RESPONSE TO SUBMISSIONS

SCEGGS Darlington -
Modification 3
SSD-8993-Mod-3

This Submissions Report relates to a Section 4.55(1A) Modification application in relation to the Concept State Significant Application (concept SSD 8993) for SCEGGS main school campus located at 215 Forbes Street, Darlinghurst (**the site**). On behalf of SCEGGS Darlinghurst Limited (**the Applicant**), this Submissions Report has been prepared to address the matters raised by public agencies, local Council, the community and other relevant stakeholders throughout the public exhibition period.

LANDSCAPE MASTERPLAN

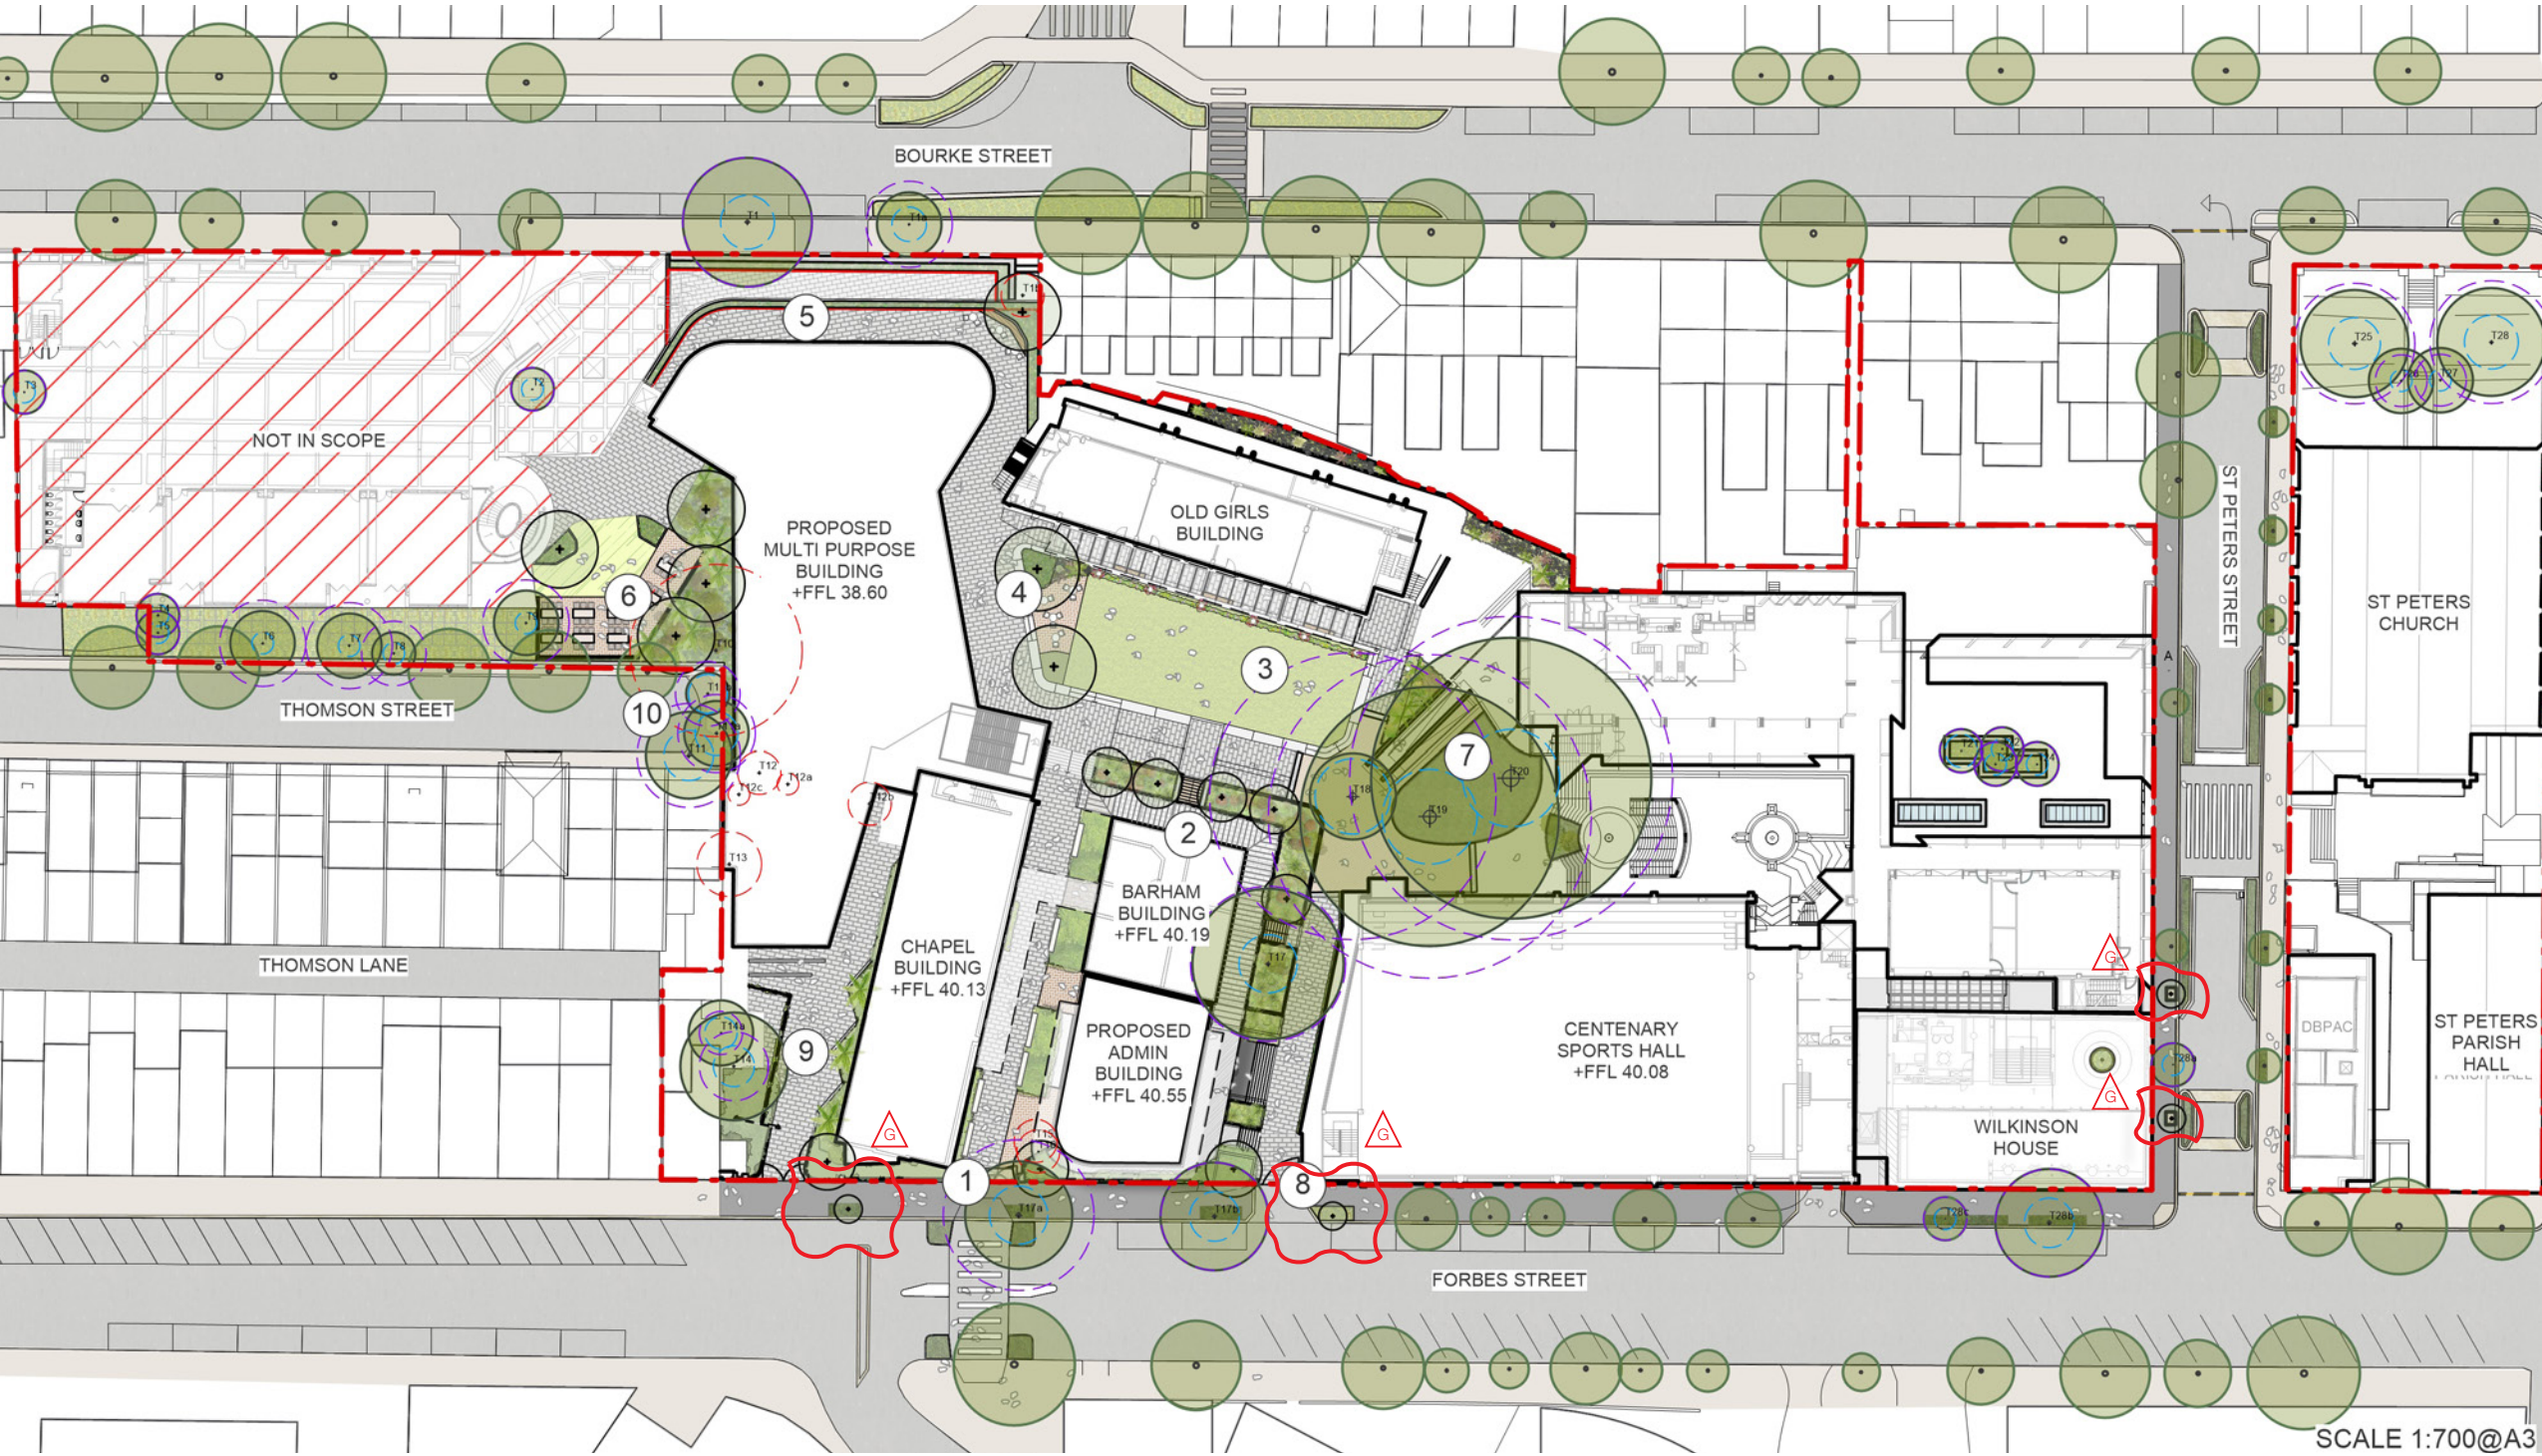
As part of the exhibition for Wilkinson House Detailed SSDA, DPE and Council requested to explore alternative landscaping opportunities within or around Wilkinson House. In response to DPE and Council, the project team proposed additional street trees along Forbes Street and St Peter Street frontages, to enhance greenery in the streetscape.

The detail of the additional trees will be documented in detailed Landscape Plan accompanying the Wilkinson House detailed SSDA RtS. For consistency, the locations of the trees are reflected on the Landscape Masterplan as illustrated below.

The tree species recommended are consistent with City of Sydney Street Tree Master Plan, and is also consistent with the existing street trees along these frontages.

Refer to the revised Landscape Masterplan (Appendix C) for further details on the landscape refinements made since public exhibition.
